CITY OF ALBUQUERQUE

April 11, 2017

**Re: Casitas De Albq.
1016 Lead SW
Traffic Circulation Layout
Architect's Stamp 03-28-17 (K13-D075)**

SITE PLAN

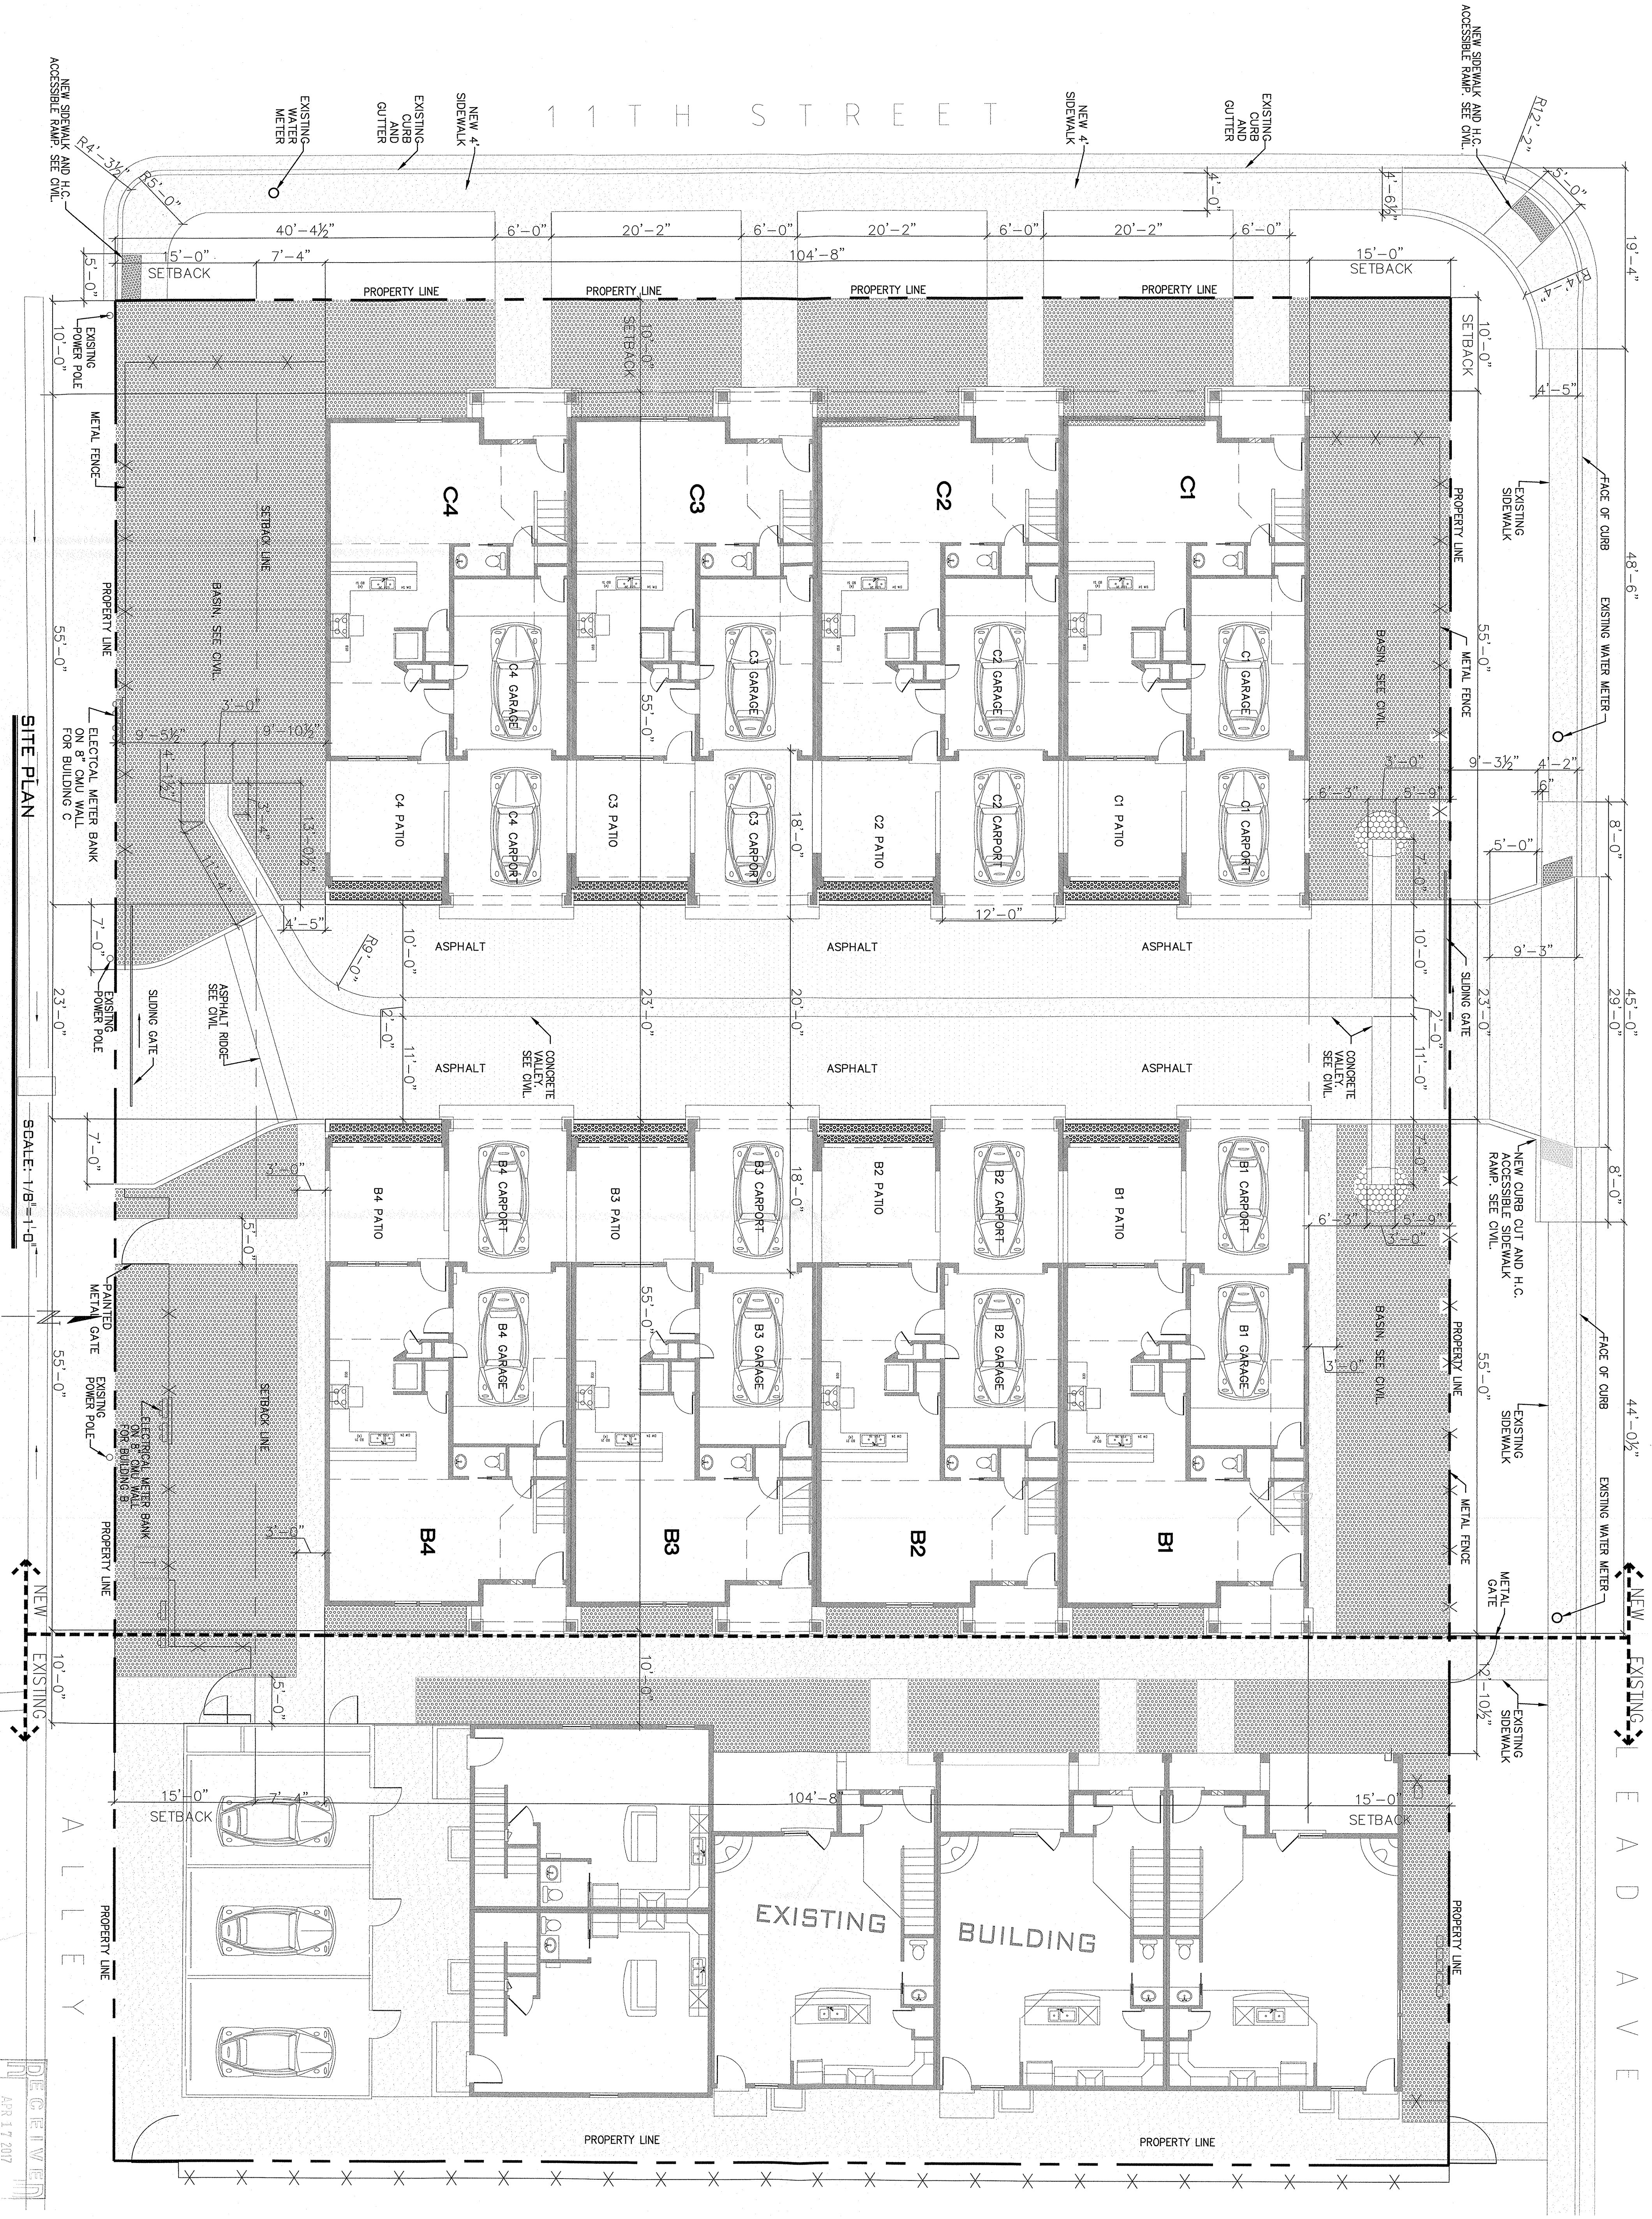
1. Clarify the extents of the current phase.
2. Identify the right of way width, medians, curb cuts, and street widths on Lead Ave.
3. Please list the width and length for all existing and proposed parking spaces. Some dimensions are not shown. Parking spaces should be 18 feet in length.

4. Please dimension all pedestrian path ways. Some dimensions are not shown.
5. Show all drive aisle widths and radii. Add dimensions to alley.
6. When building new ADA curb ramp on the south end of the frontage, align the ramp with the sidewalk on the other side.

7. Per the zoning code, a 6 ft. wide ADA accessible pedestrian pathway is required from the public sidewalk to the building entrances. Please clearly show this pathway and provide details.

8. Please specify the City Standard Drawing Number when applicable. 2430 for new sidewalk and any other standards that apply.
9. Unused curb cuts must be replaced with sidewalk and curb & gutter. A build note must be provided referring to the appropriate City Standard drawing.

10. Please add the following note to the clear sight triangle: "Landscaping and signage will not interfere with clear sight requirements. Therefore, signs, walls, trees, and shrubbery between 3 and 8 feet tall (as measured from the gutter pan) will not be acceptable in this area."
